20th April 2021

Application No: BE/37/21/HH
Site Address: 19 South Way Bersted PO21 5HB
Description of works: Removal of 3 No existing lean-to structures, erection of single storey side & rear extension, loft conversion to form new 2nd floor with roof alterations to form gable end with rear dormer projection & detached outbuilding to be used as annexe to existing dwelling.

PROPOSED DETACHED OUTBUILDING AT 19, SOUTH WAY, BOGNOR REGIS
FOR MR.O.SAPOZHNYK.

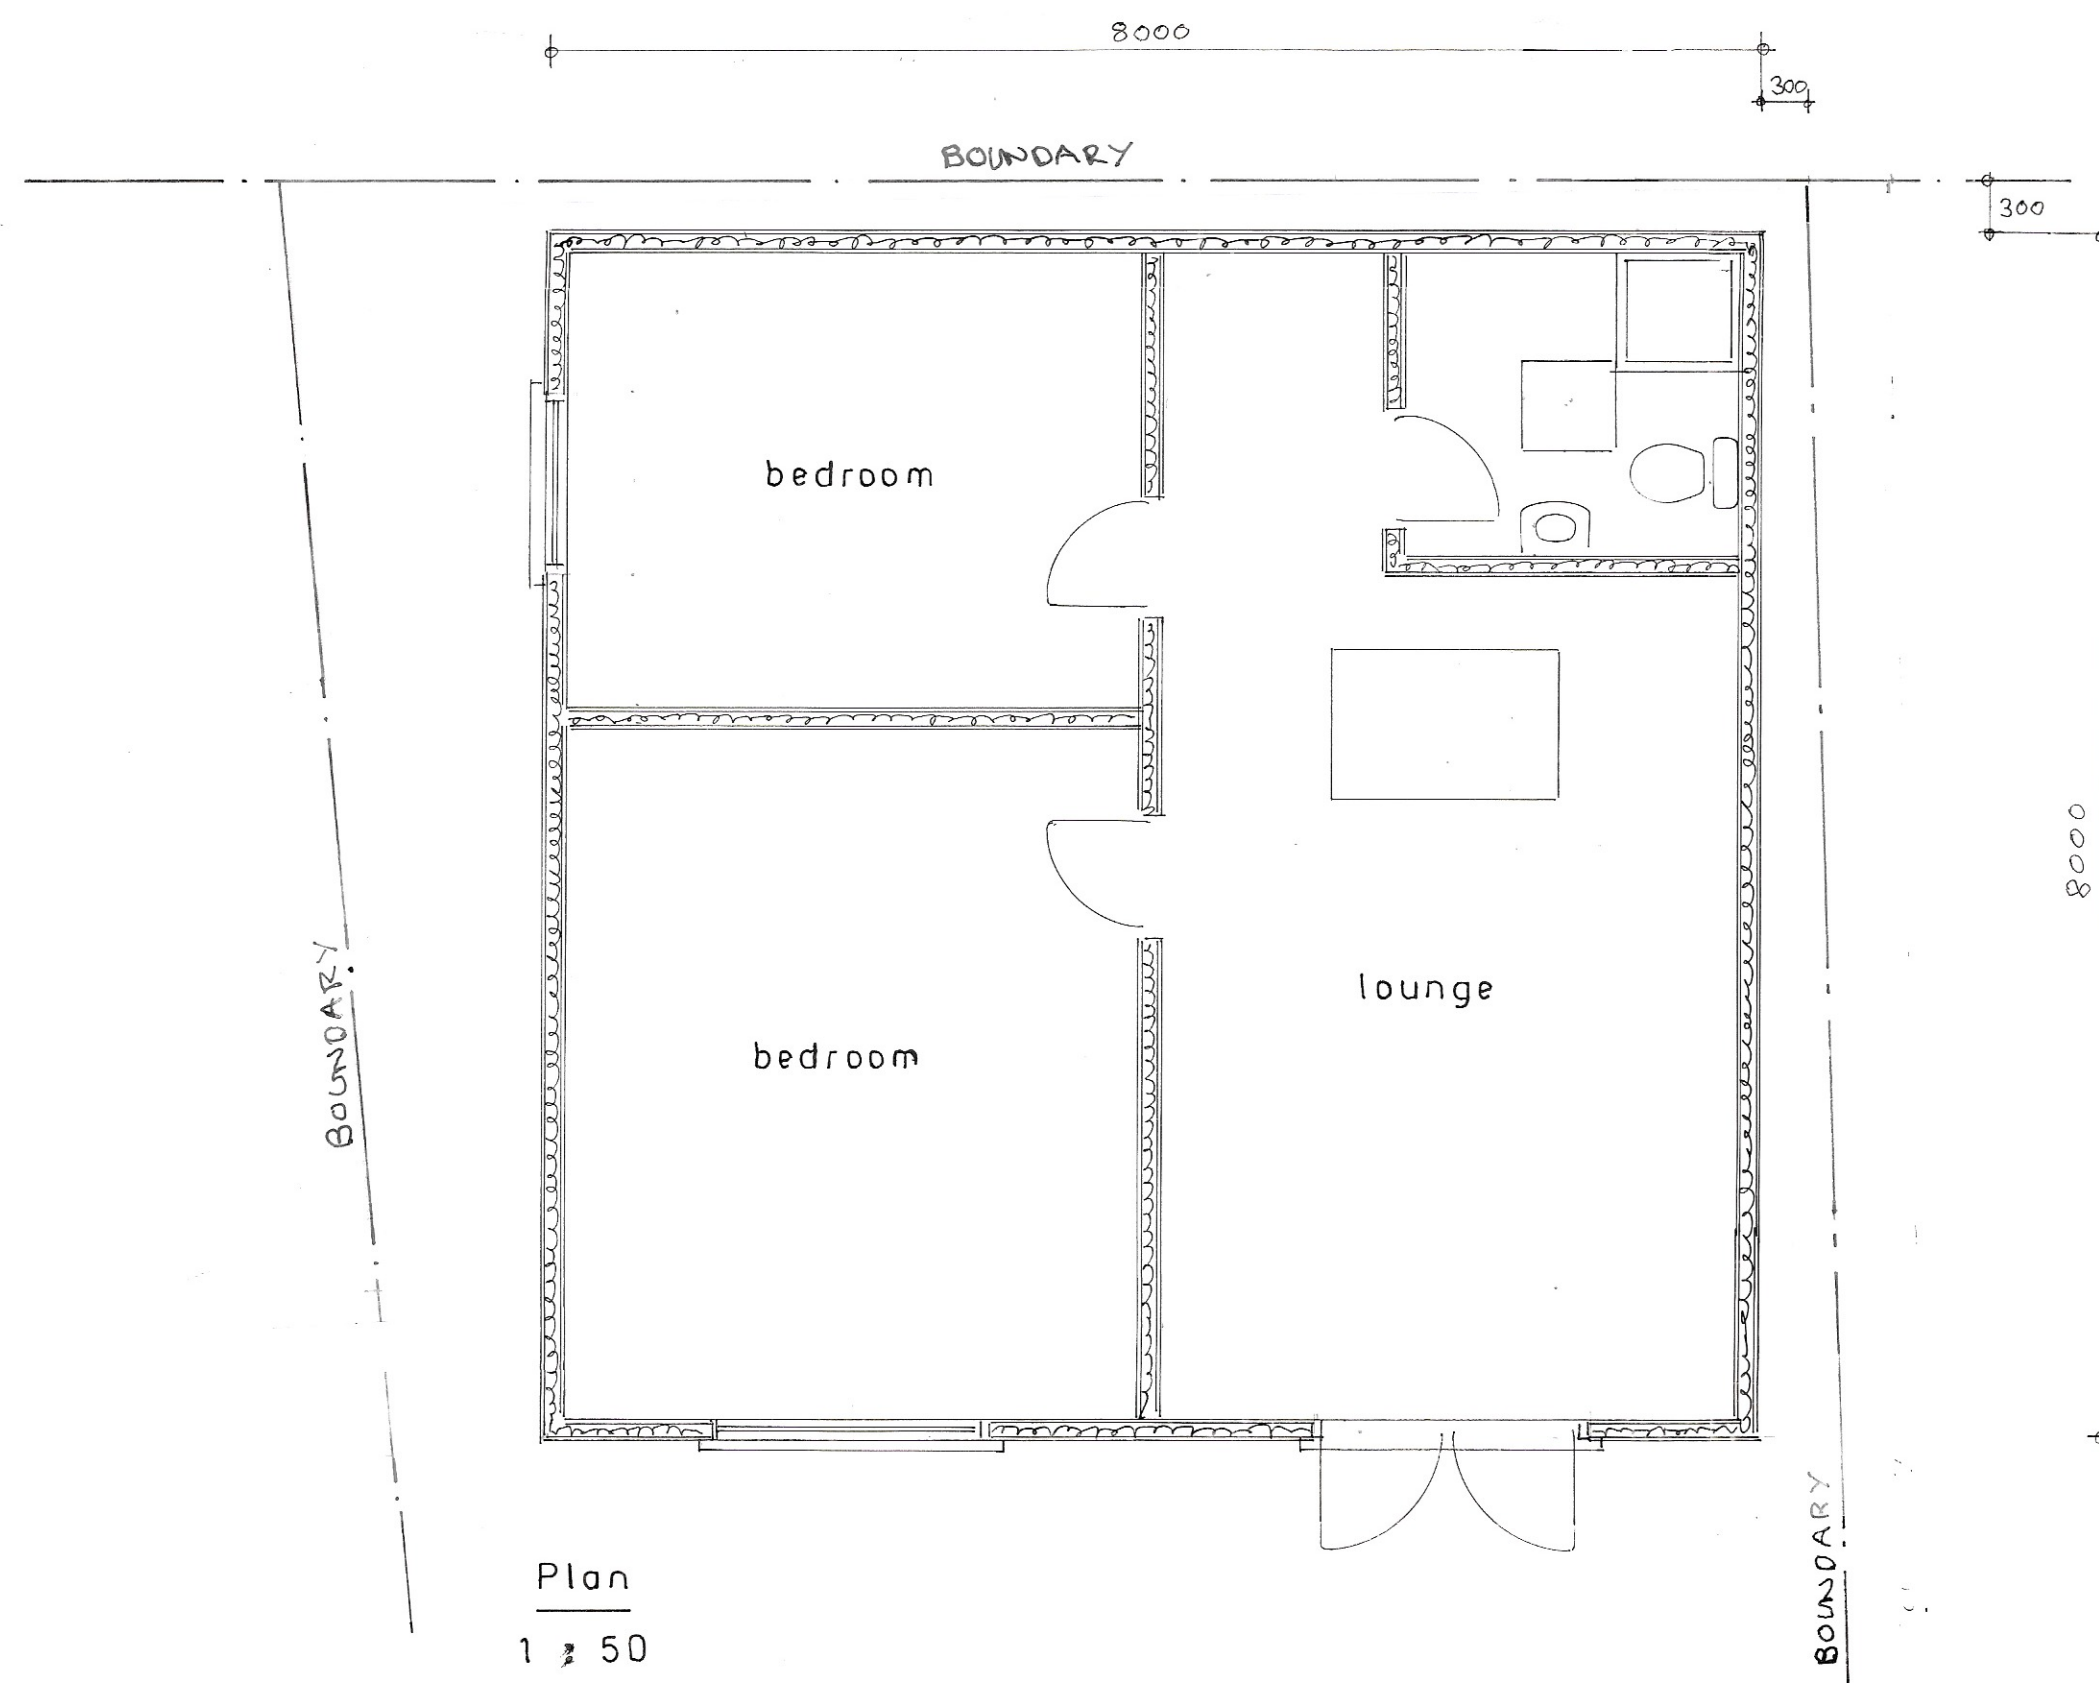
The proposed design for the redevelopment work including new build annexe to 19 Southway would appear to conflict with "residential" as the proposal clearly shows an office, with a separate front entrance to the main property, which leads to a bedroom. This suggests the the property would be used for a mixture of residential/commercial when the application is for residential. The proposals would suggest that the property could be used as an HMO as per the definition on Arun District Council's website. There is no intention of installing a Kitchen, one would normally be required in a family residence. The CIL does not refer to the office under non residential floor space and therefore questions the intention of intended use of the property.
